Application No: EP/47/21/HH
Site Address: West House South Strand East Preston BN16 1PN
Description of works: Erection of second floor addition, part single storey side, part two storey front, side and rear extensions and alterations to fenestration/openings

OWQC36496

This council's Planning & Licensing Committee has considered this Application electronically.

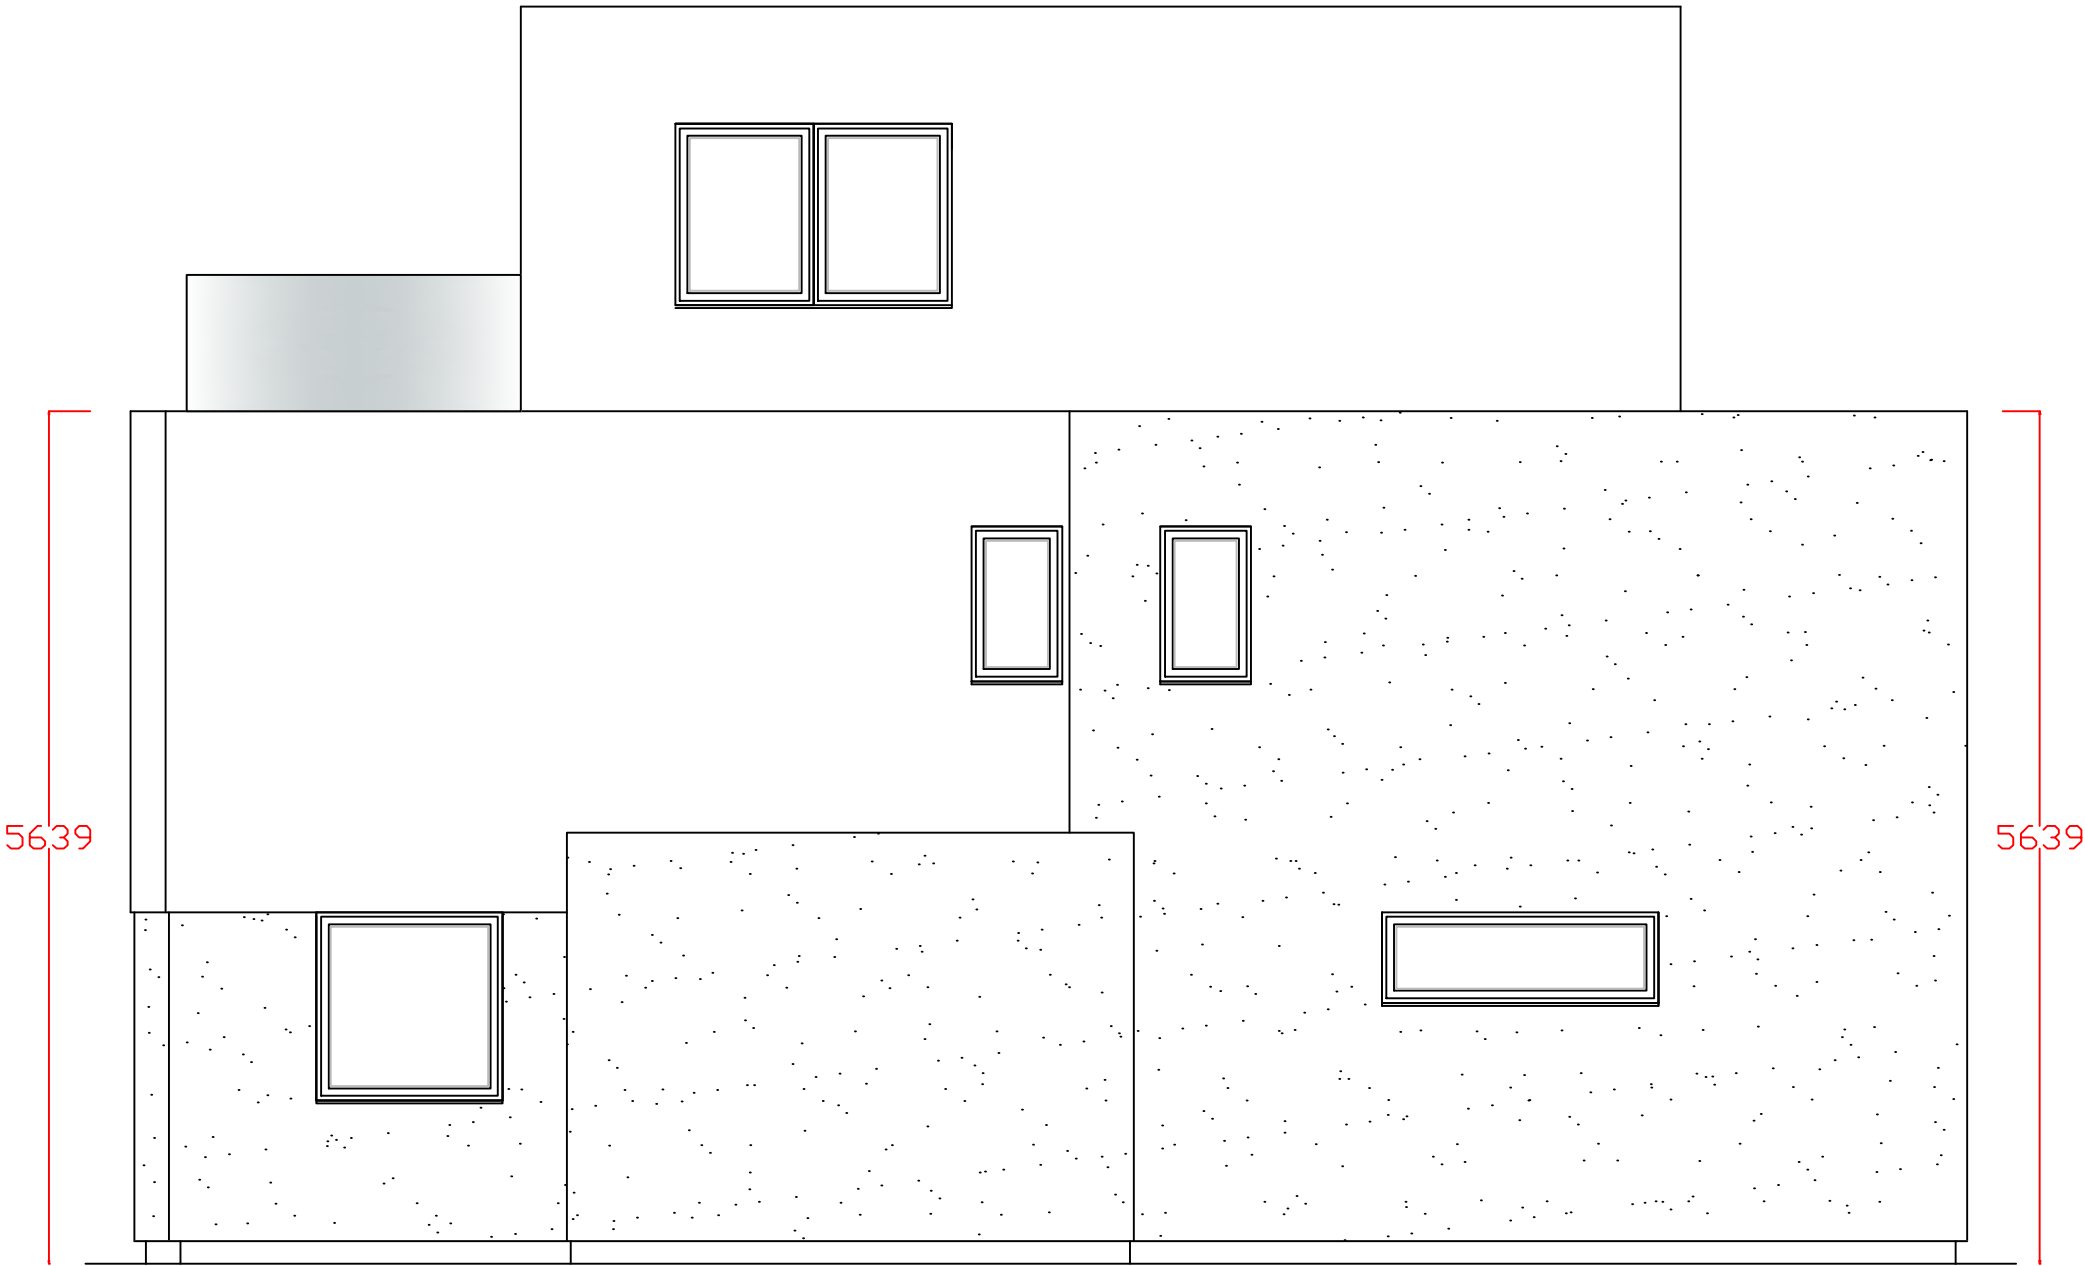
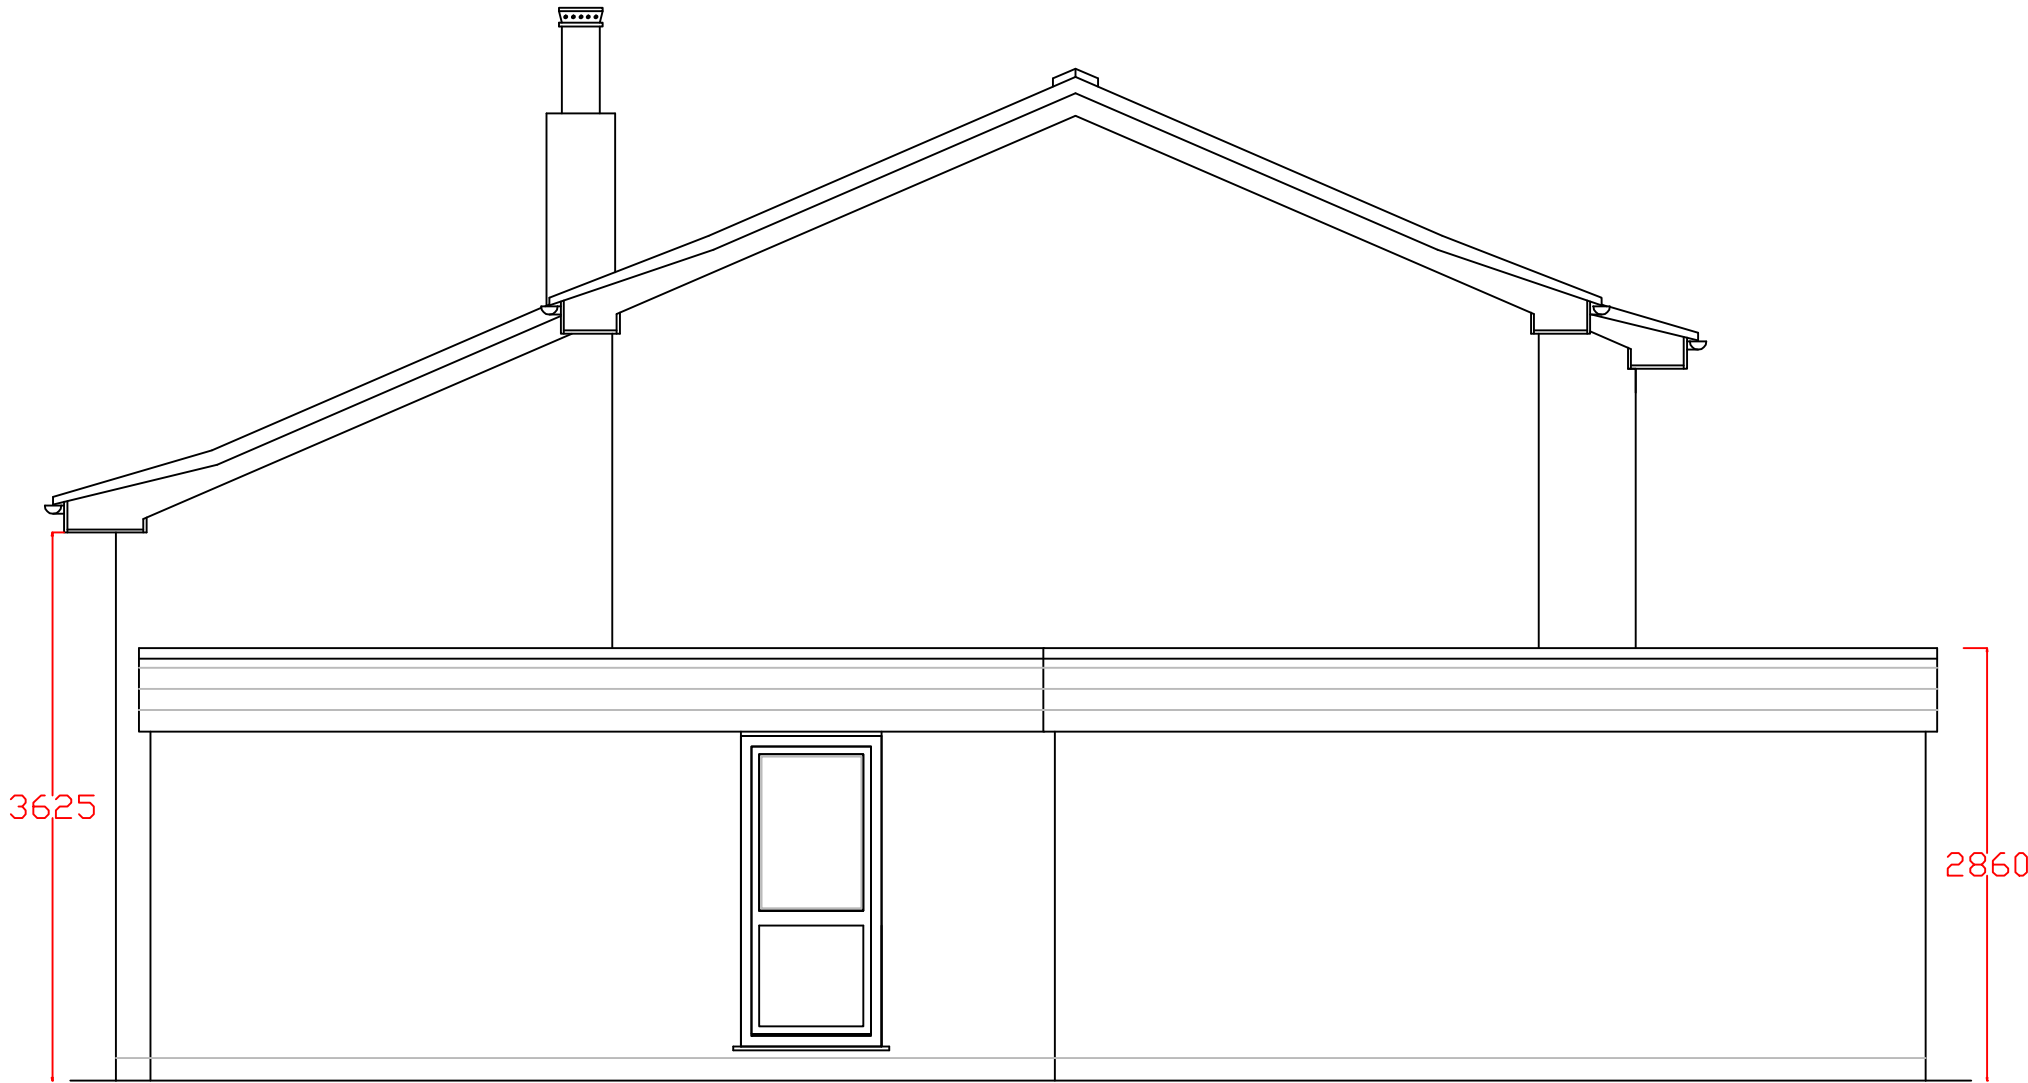
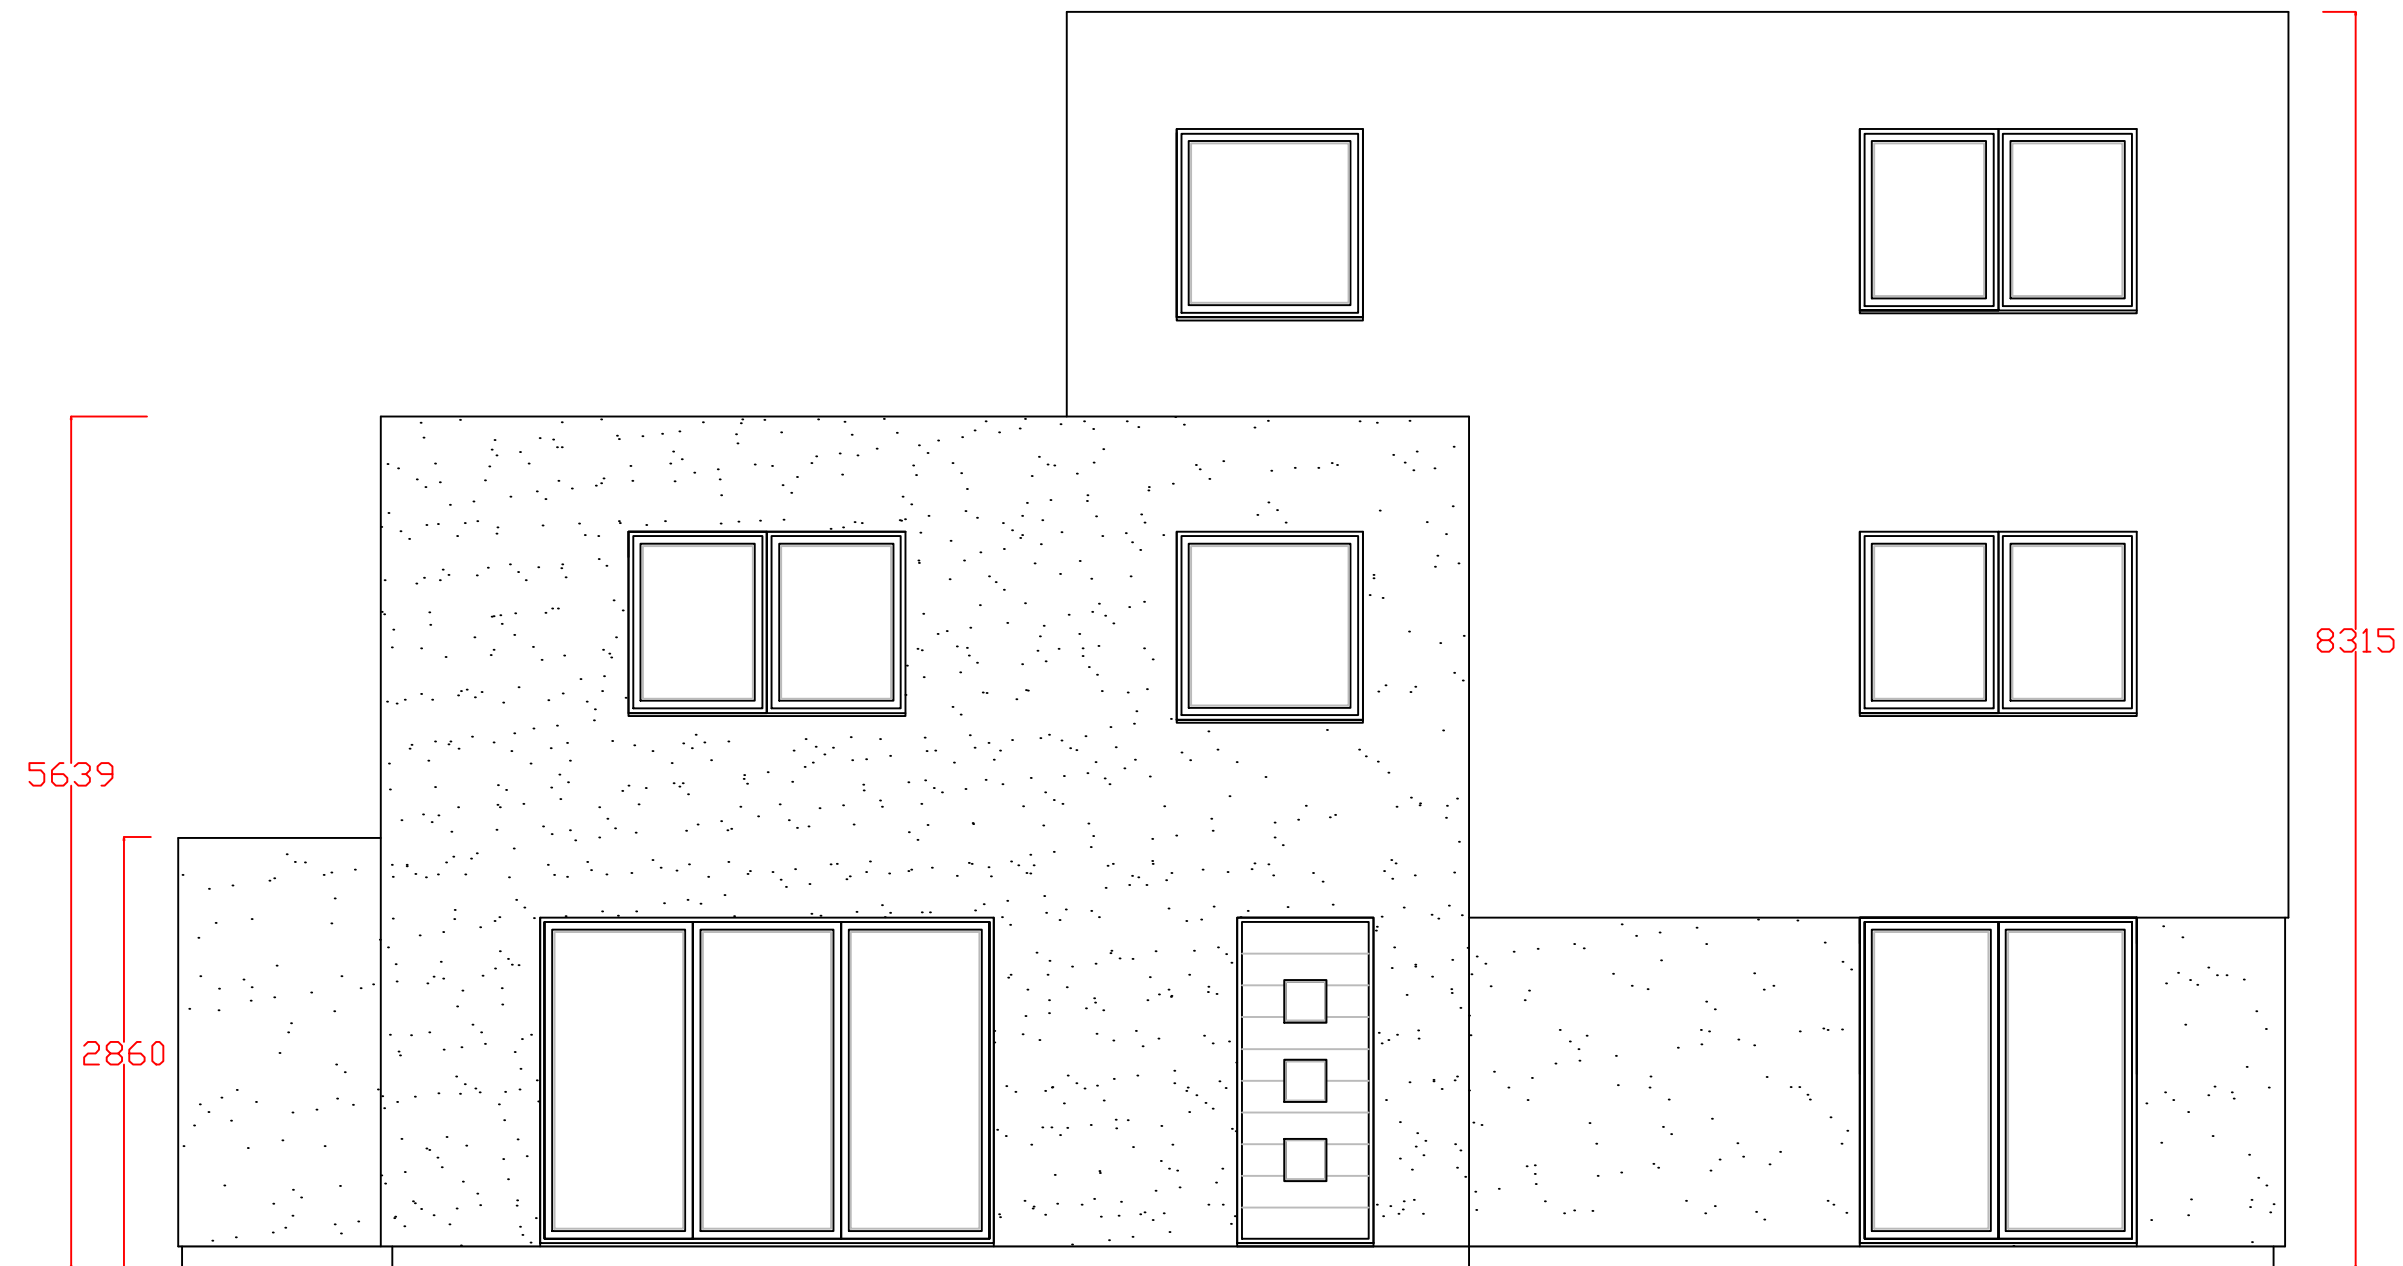
The proposed materials do not harmonise in both colour and texture with the materials used in adjoining buildings thus conflicting with Policy 1 of the Neighbourhood Plan. This council does not believe Rockpanel cladding of the sort described in the application form is not visible on any building in the vicinity of West House.
